22nd September 2016

Objection to Application Reference 6/2016/1778/FULL. Concerning 11 Brookmans Avenue AL9 7QH

Drawing Title
PROPOSED PLANS/SECTION/
ELEVATIONS

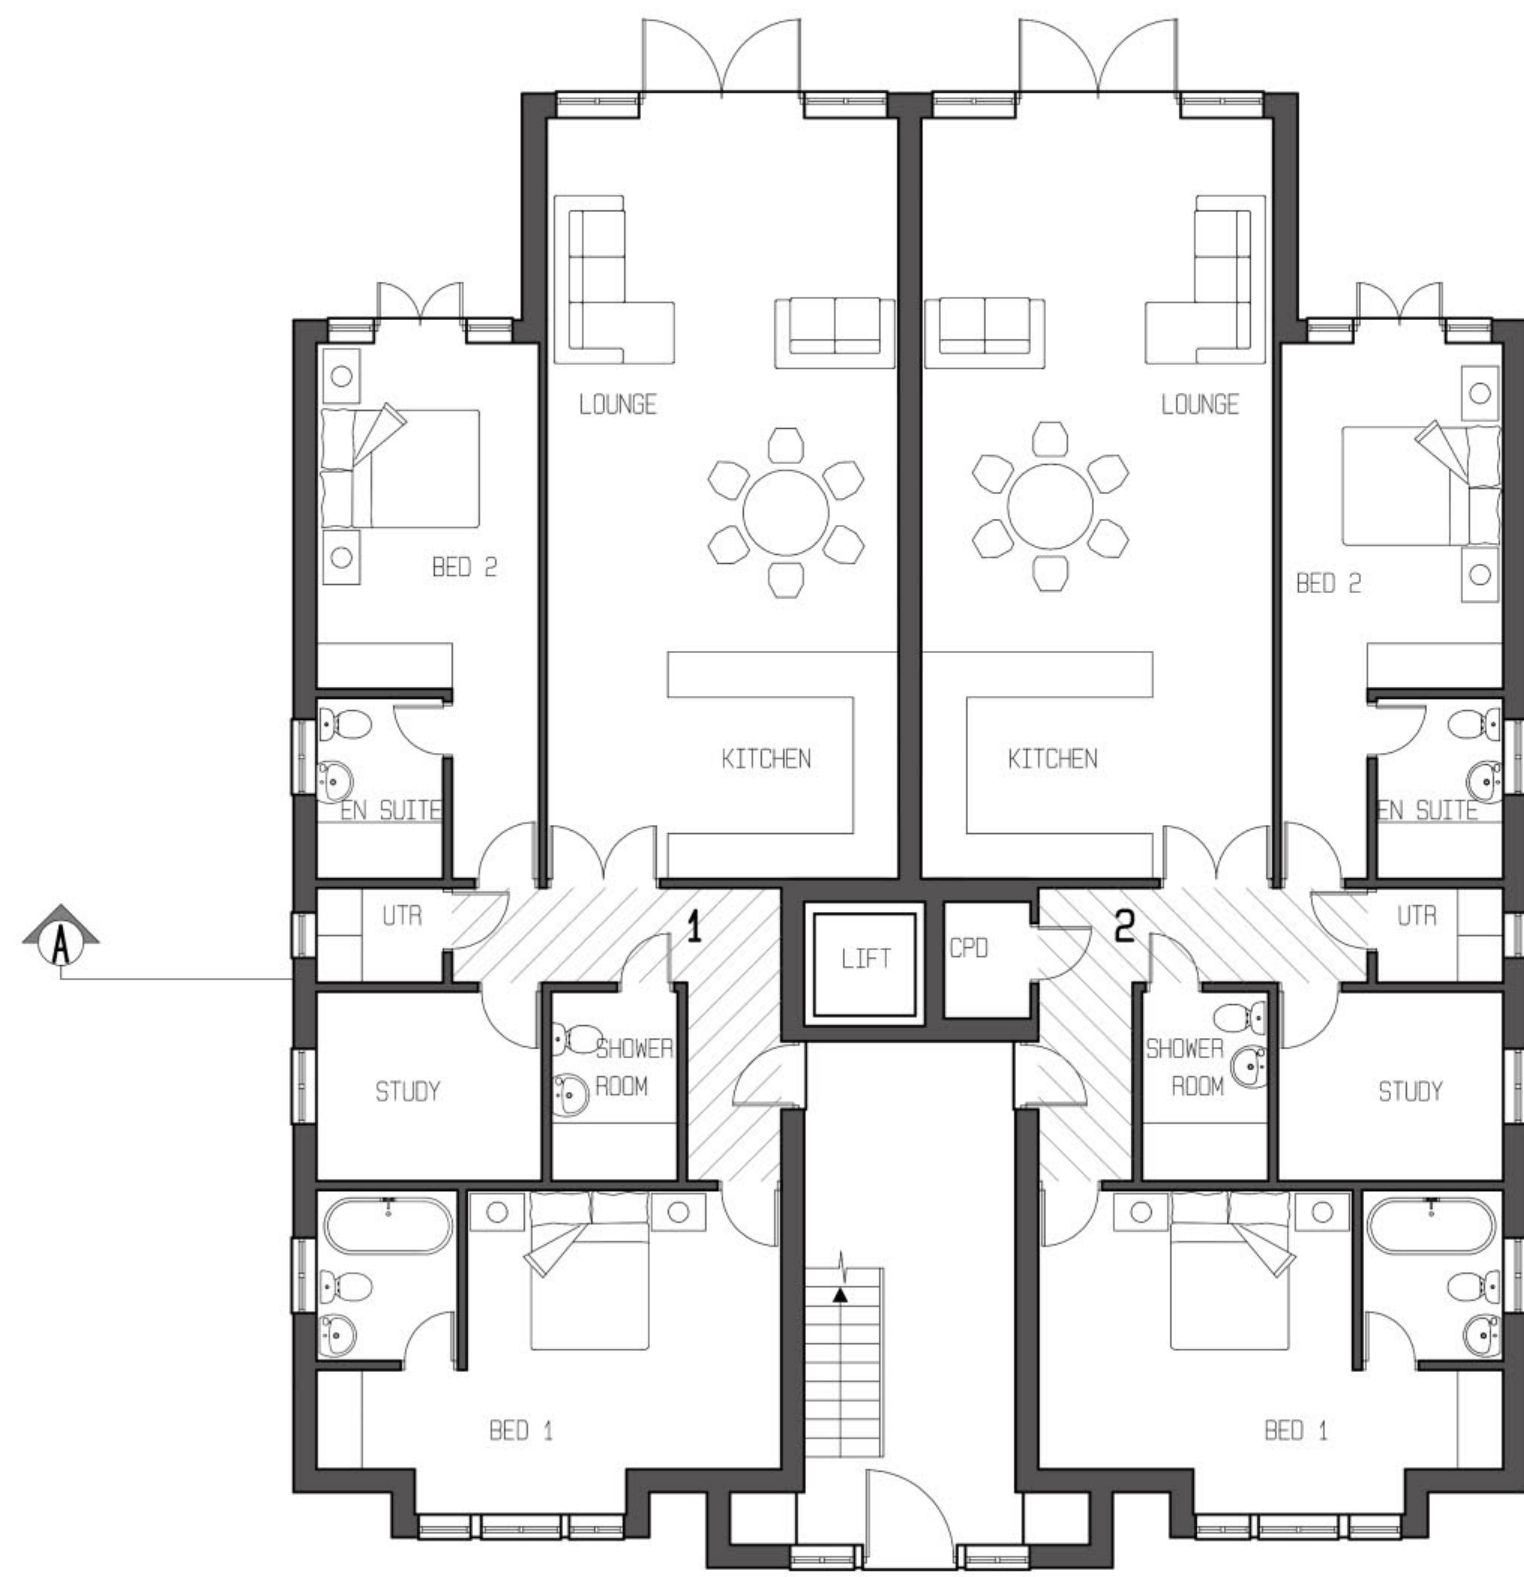
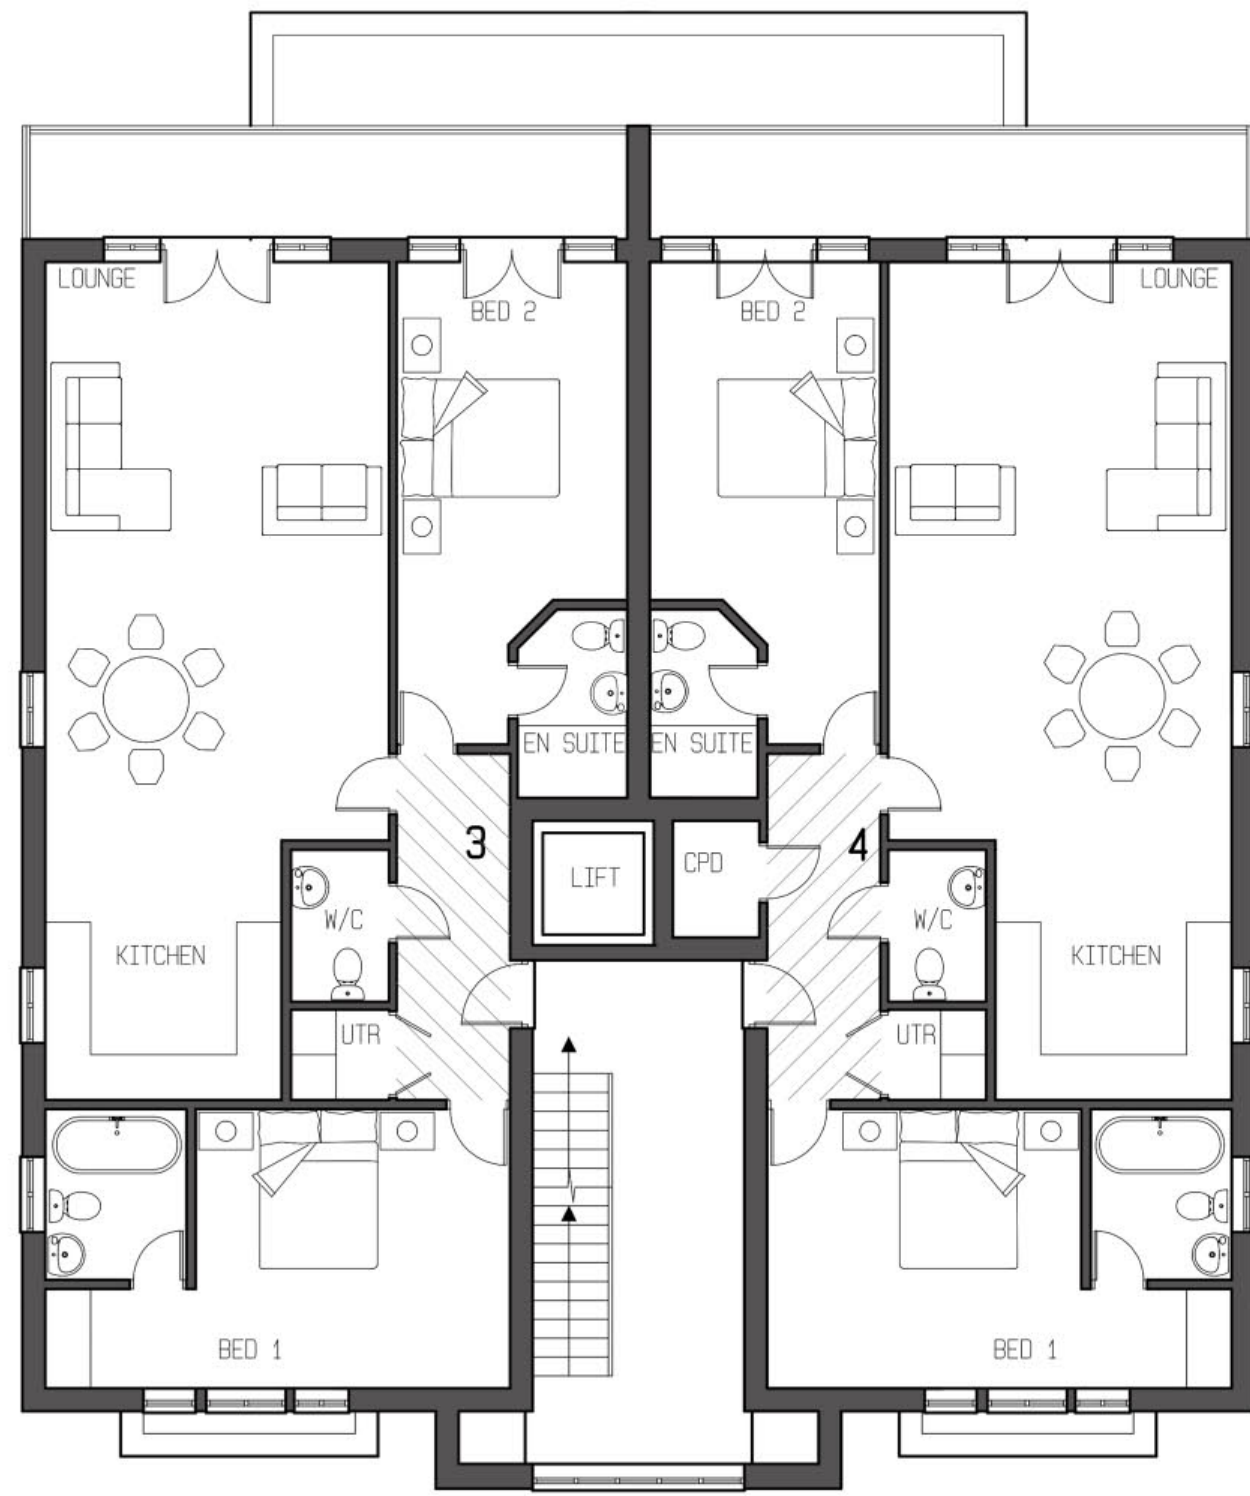
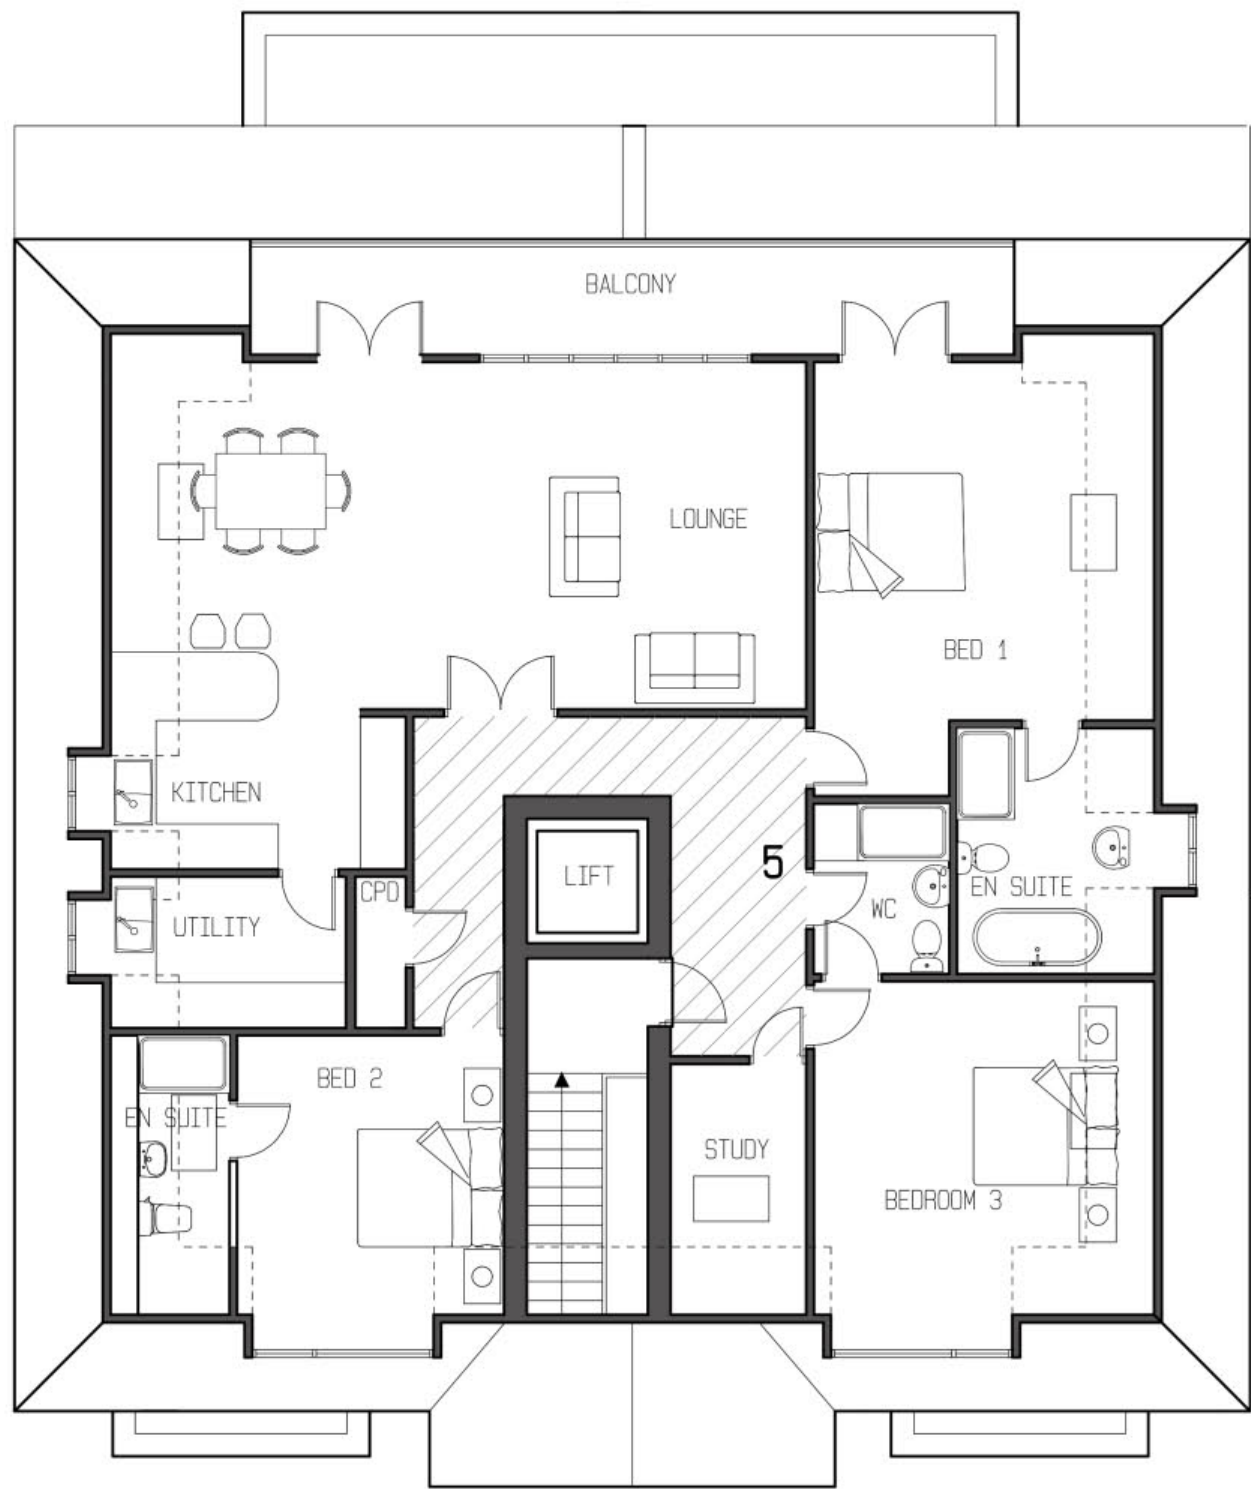
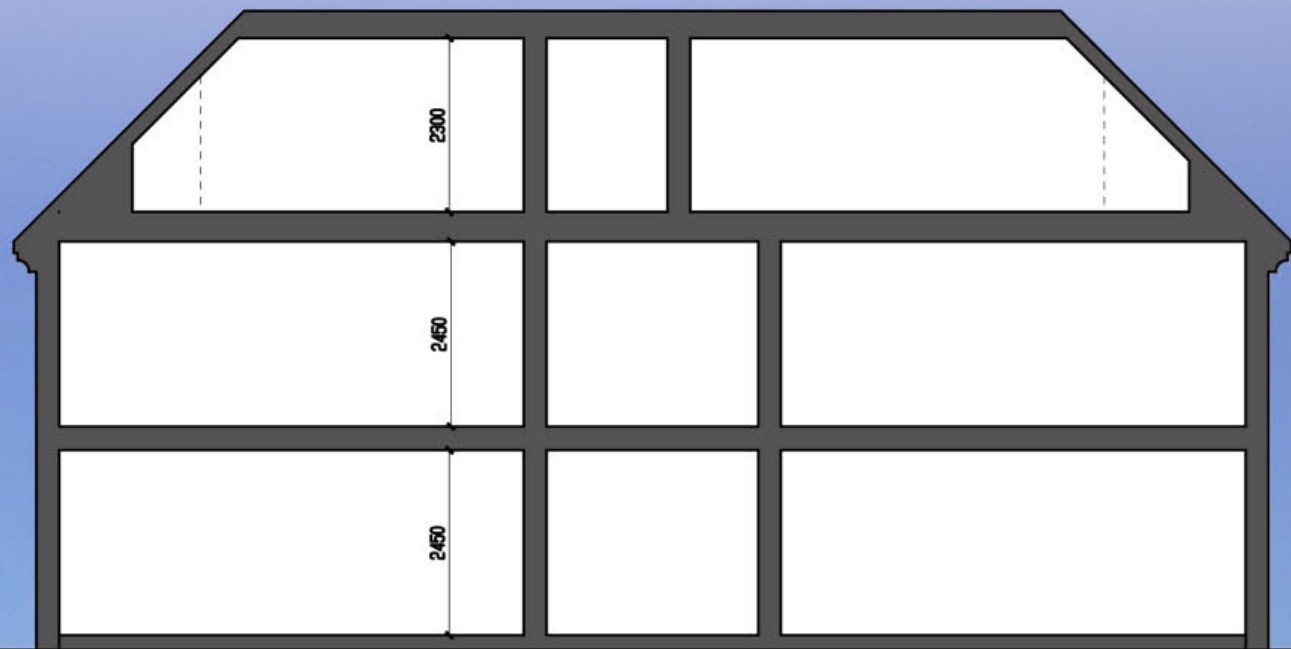
1. The addition of third floor dormer windows overlooking and facing the major aspect of our property. These appear to have been added to the original building design that was shown to us by the developer, these third floor windows being out of keeping with the adjacent properties 9A and 13.

Drawing Title
 PROPOSED SITE PLAN AND
 STREET SCENE

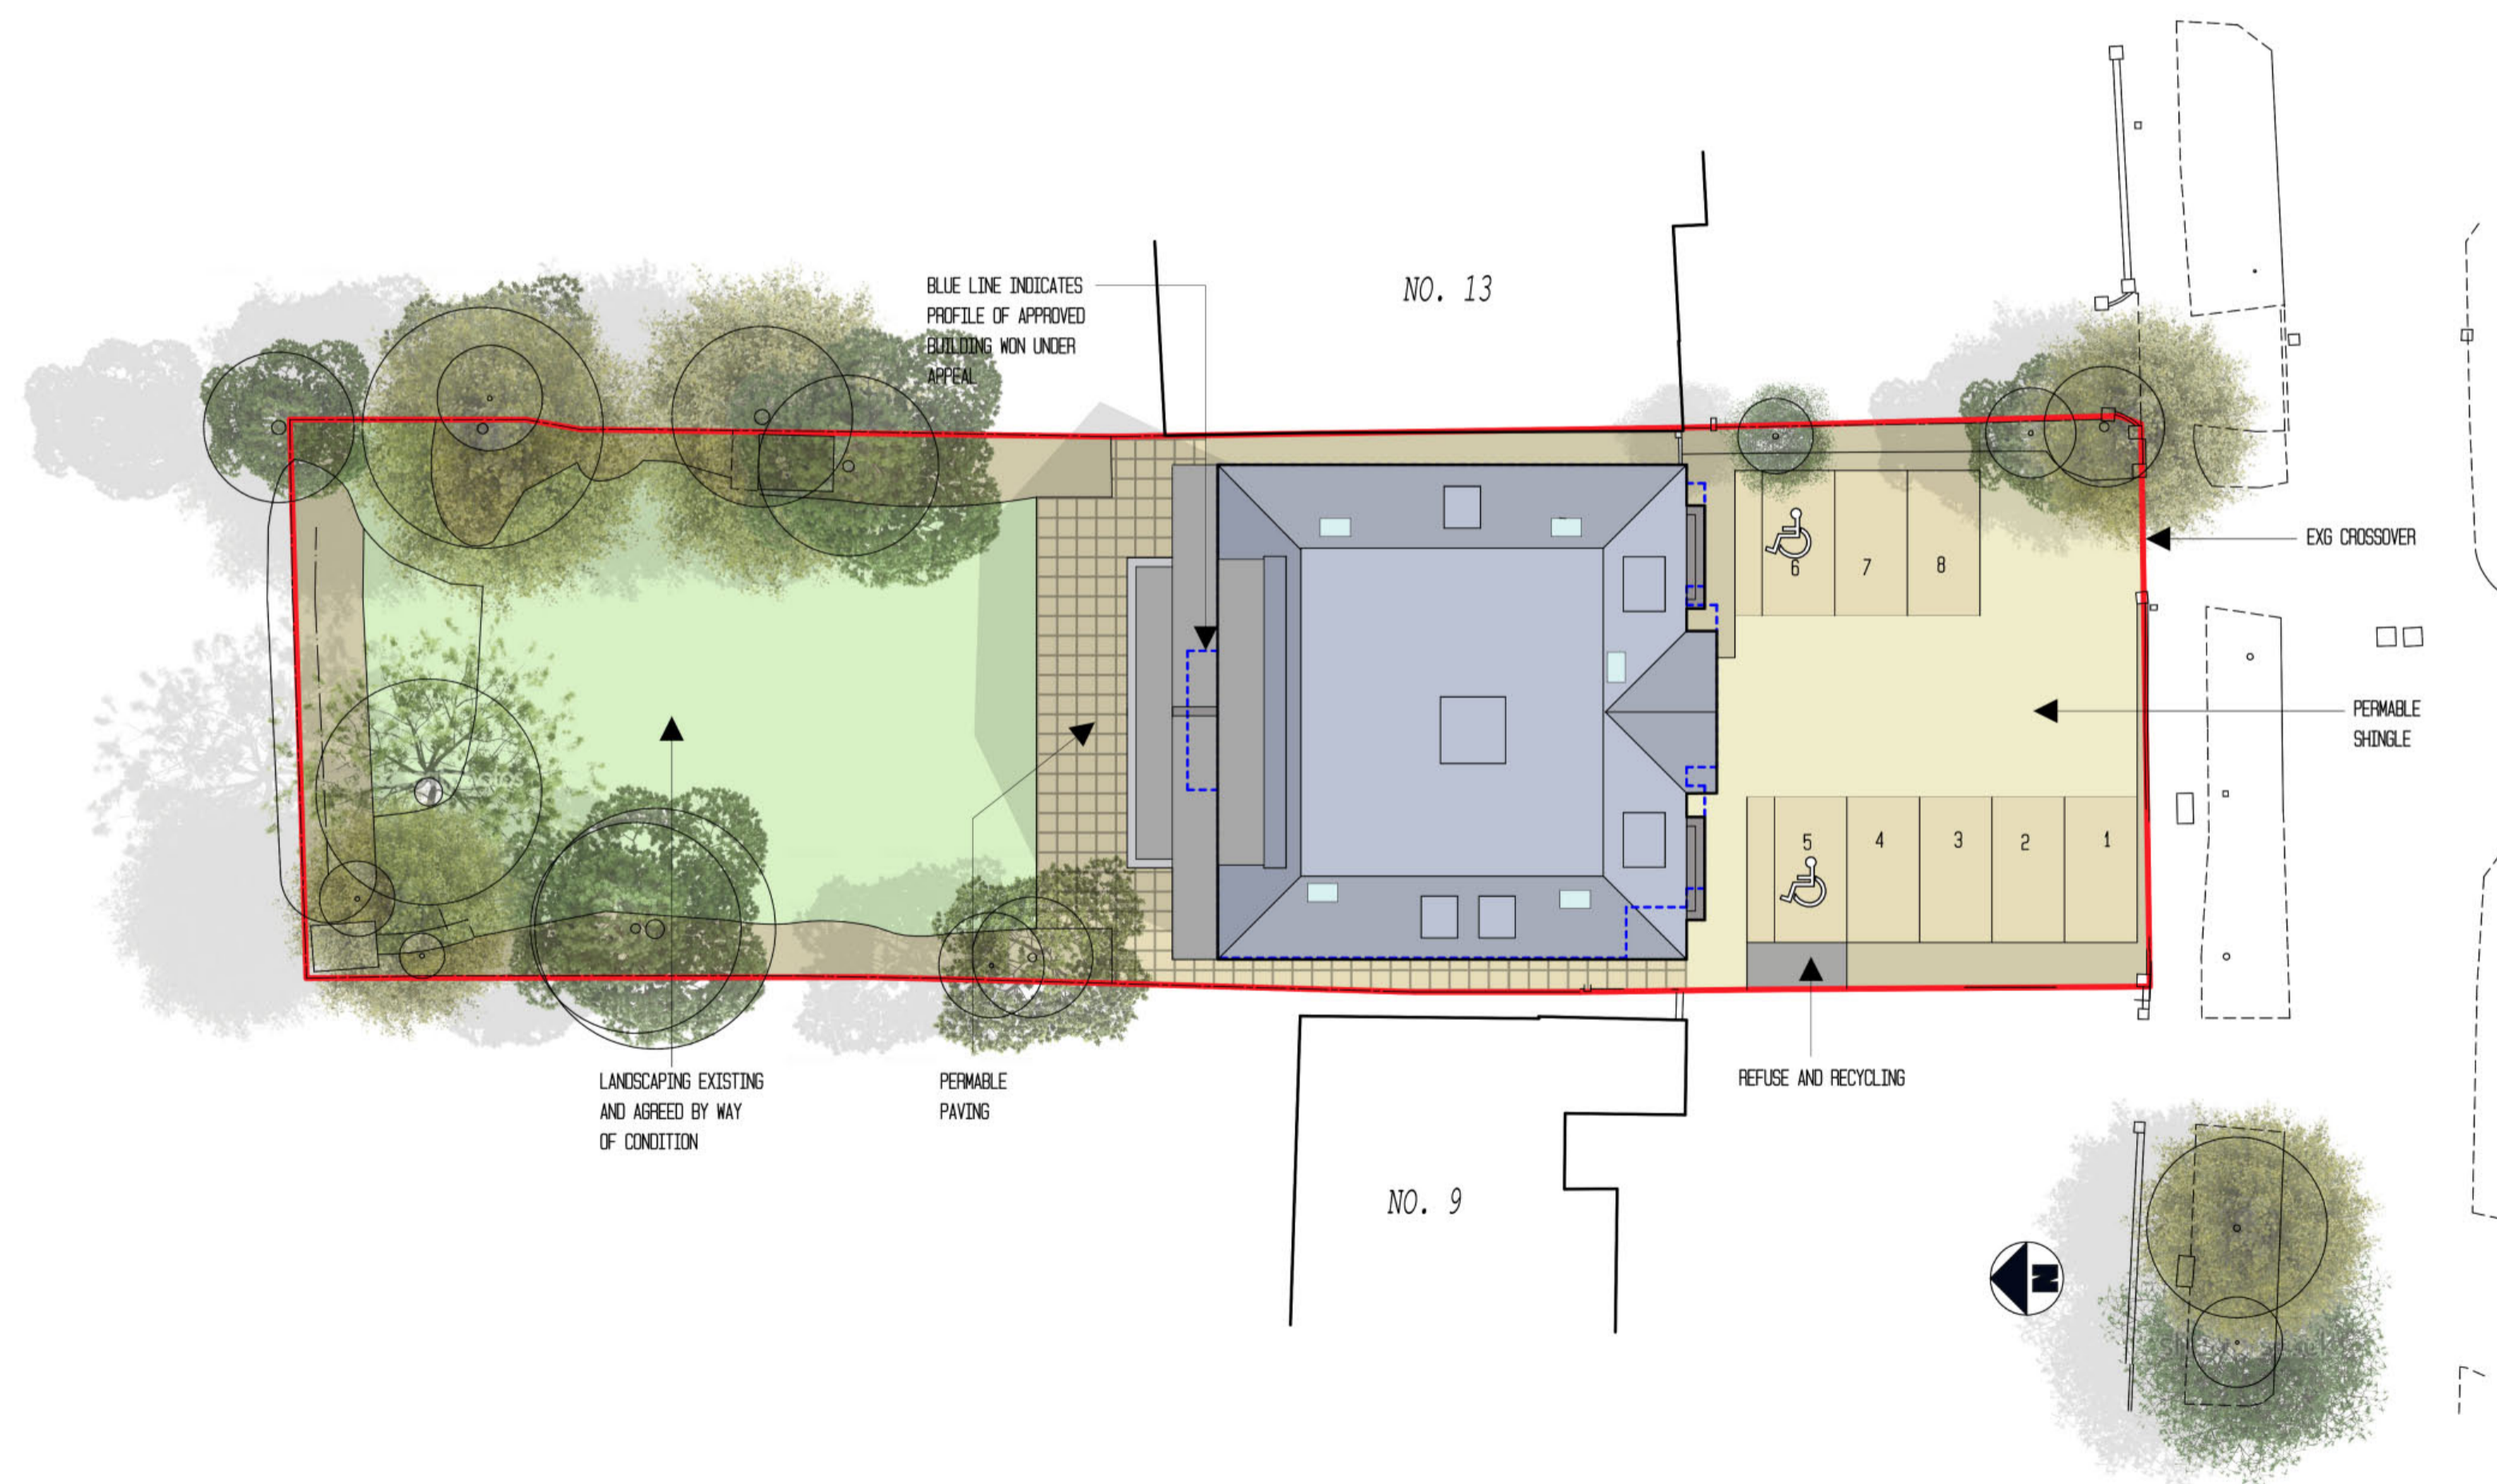
2. Insufficient resident parking and inadequate access for delivery or emergency vehicles. There is already a shortage of street parking space in this area and it is already common for occupants of flats surrounding Bradmore Green to park one or more cars/flat overnight in Brookmans Avenue. Assuming residents of each of the applied for flats own on average two cars then there will need to be at least ten assigned parking places plus visitor, delivery and emergency vehicle parking. This shortage of parking space might be overcome by setting the building back and providing adequate natural drainage to the enlarged parking area.
